Recommendation Report for Planning Permission for Works or Extension to a Dwelling

REF NO: AW/77/20/HH

LOCATION: 1 Willow way
Aldwick
PO21 4NA

PROPOSAL: Single storey front extension.

sheet 1 of 2

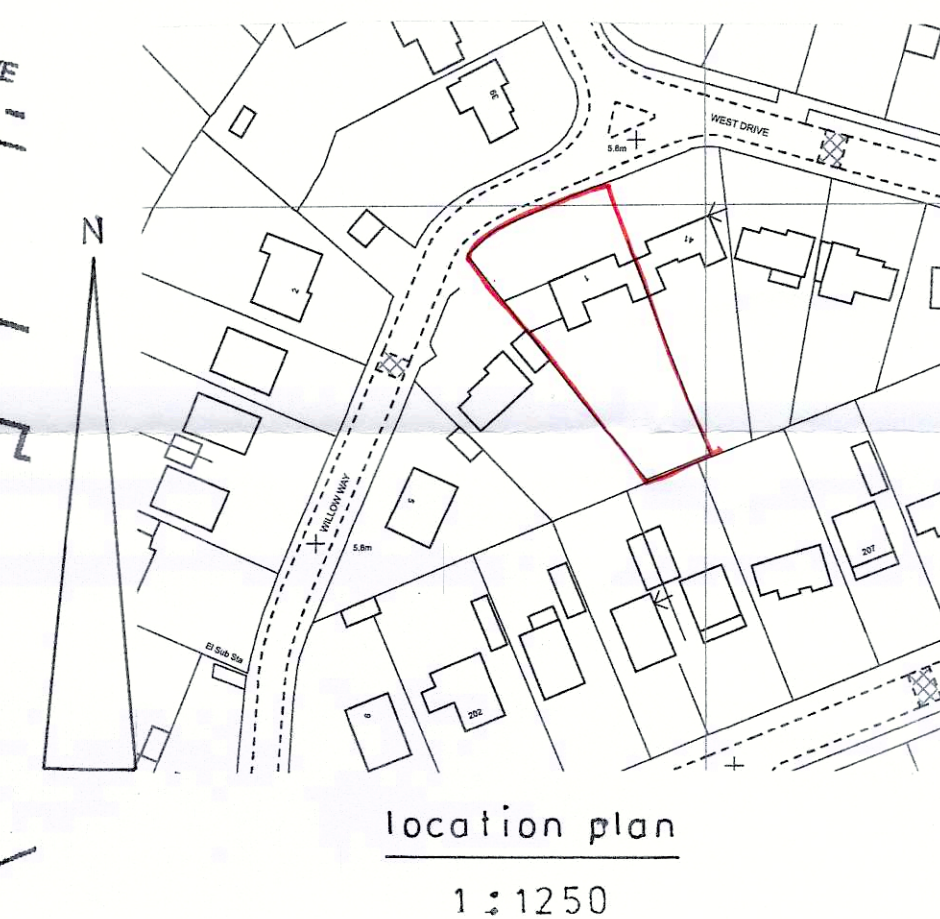
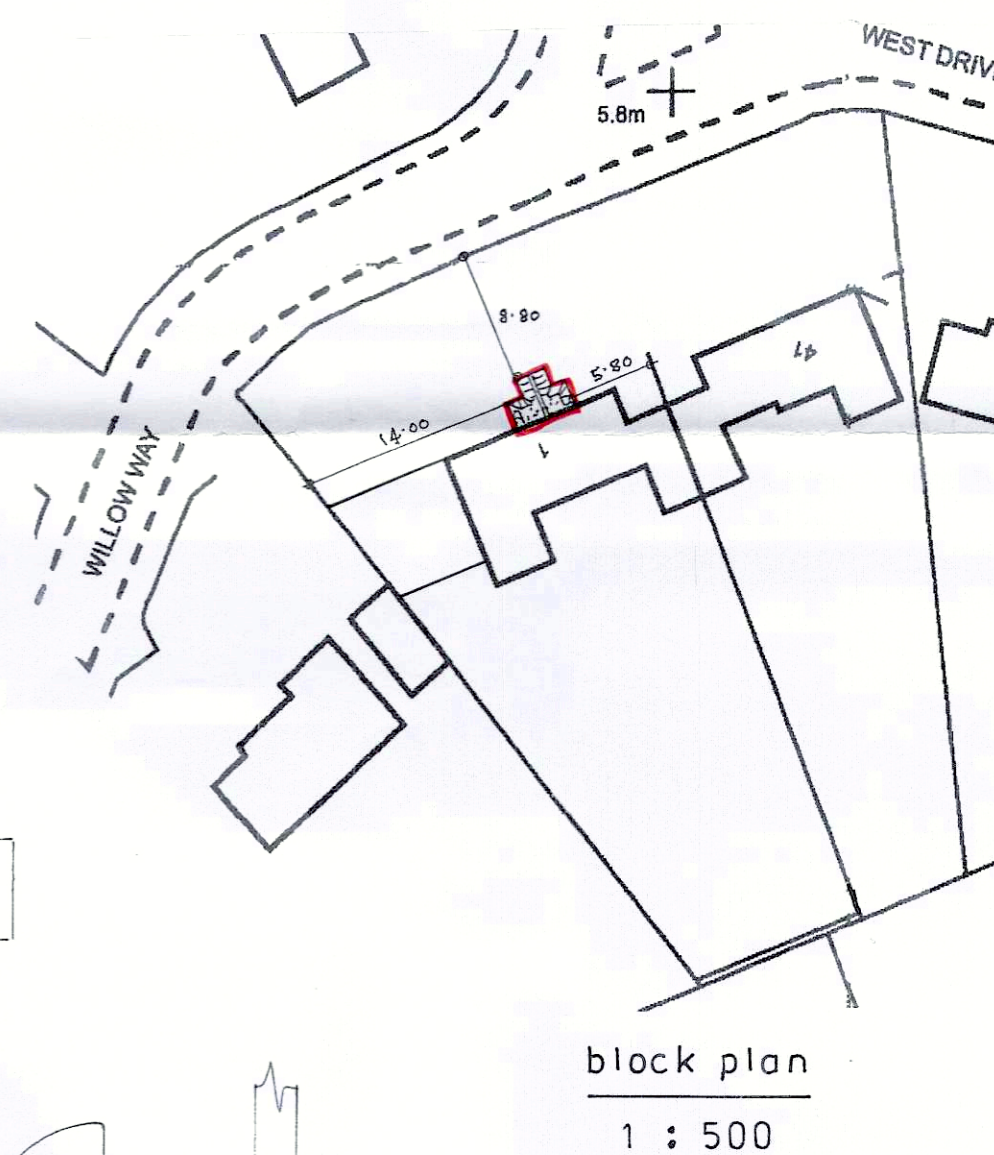
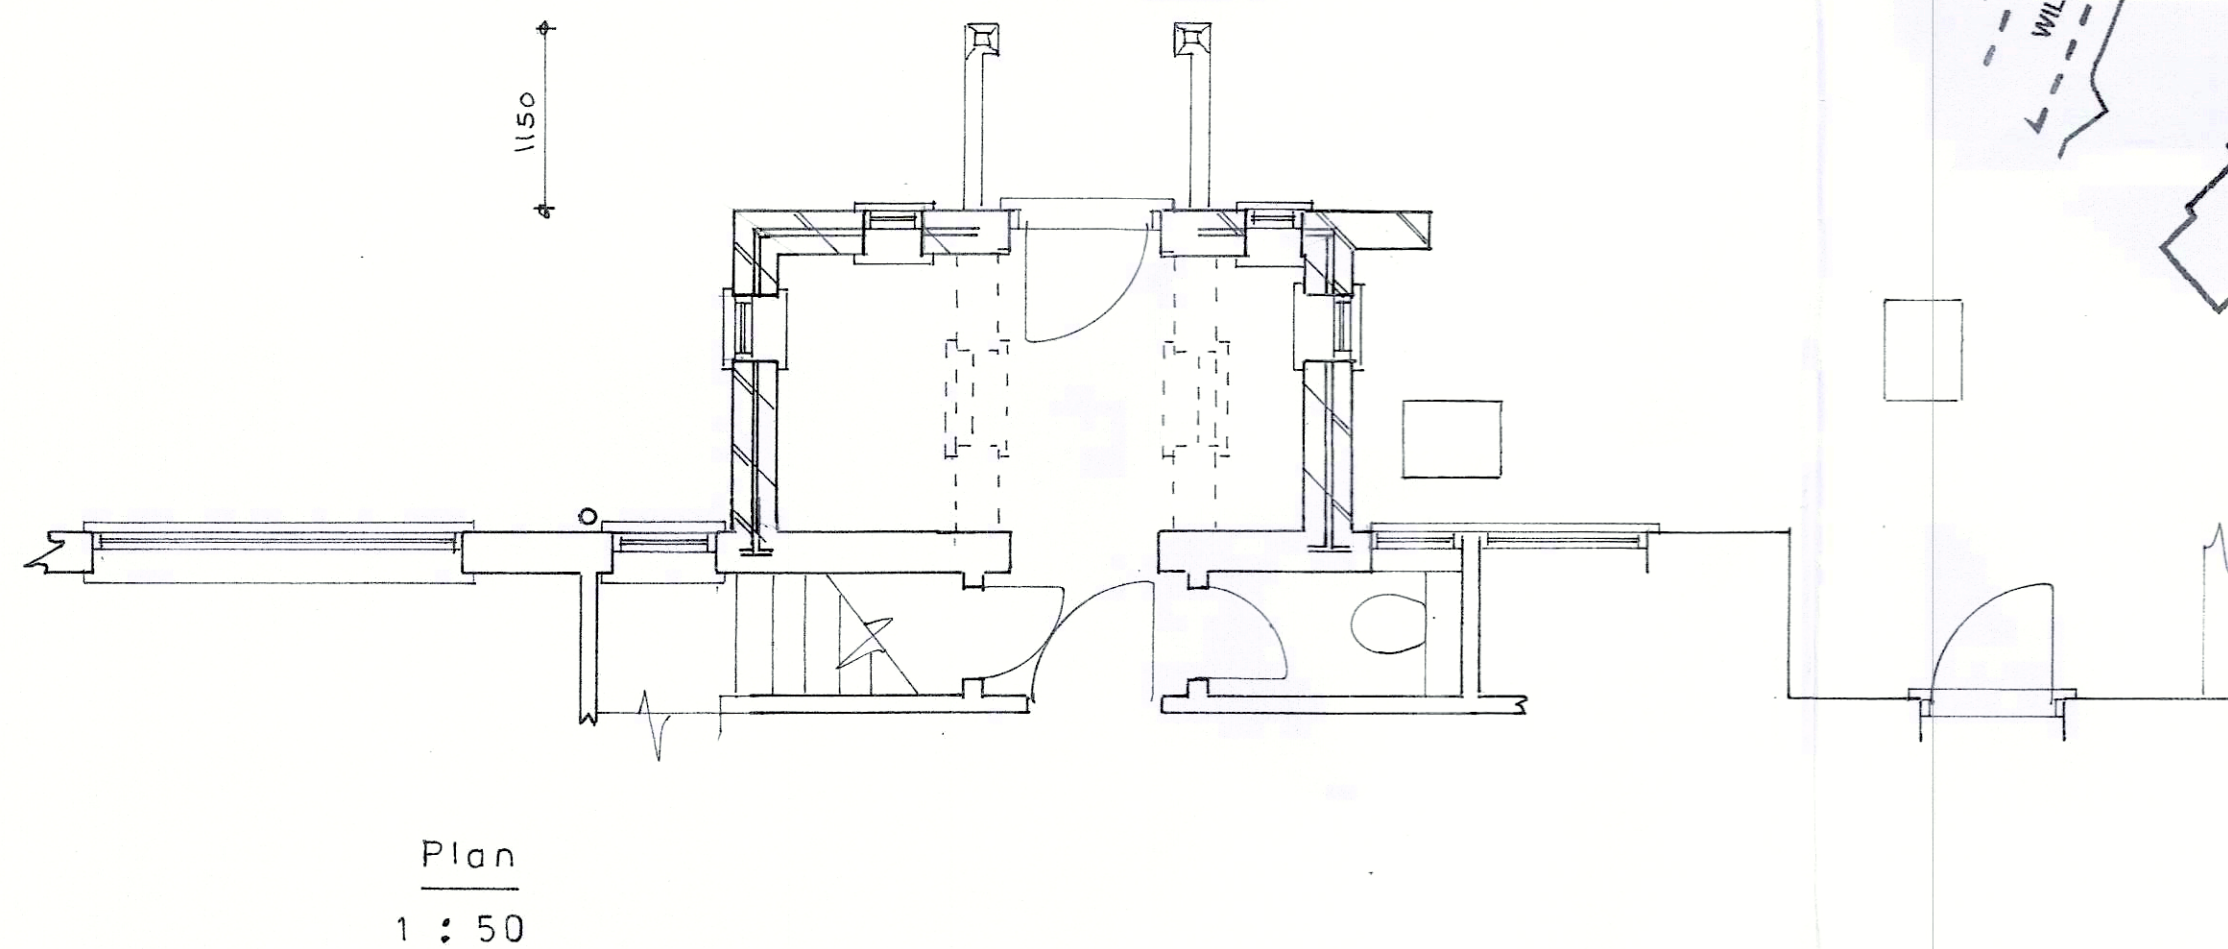
The extension is to the front side of the dwelling. The extension will have a pitched roof to match the existing.

Surrounding properties are similar in style and the alteration by reason of its size, design and position is not deemed to result in the dwelling appearing out of character. The addition whilst fronting the street scene appears subservient and well integrated with the use of matching materials.

The extension does not appear unduly dominant, meeting with the principle elevation and retaining 8.8m is retained to the northern boundary.

The extension will have a width of 4.7m a depth of 3.45m and the height will be around 3.35m. Due to the siting, the addition is not considered to result in an adverse overbearing or overshadowing upon neighbouring amenity with sufficient separation.

There will be 2 windows and a door to the southern elevation. This fronts the neighbouring property however overlooks the front garden and entrance and is not considered to result in views additional to that already achieved. There will be a small window on both the east and west elevations, again these being ground floor and located to the front of the property are not considered to result in unacceptable levels of viewing that does not already exist from the street scene.
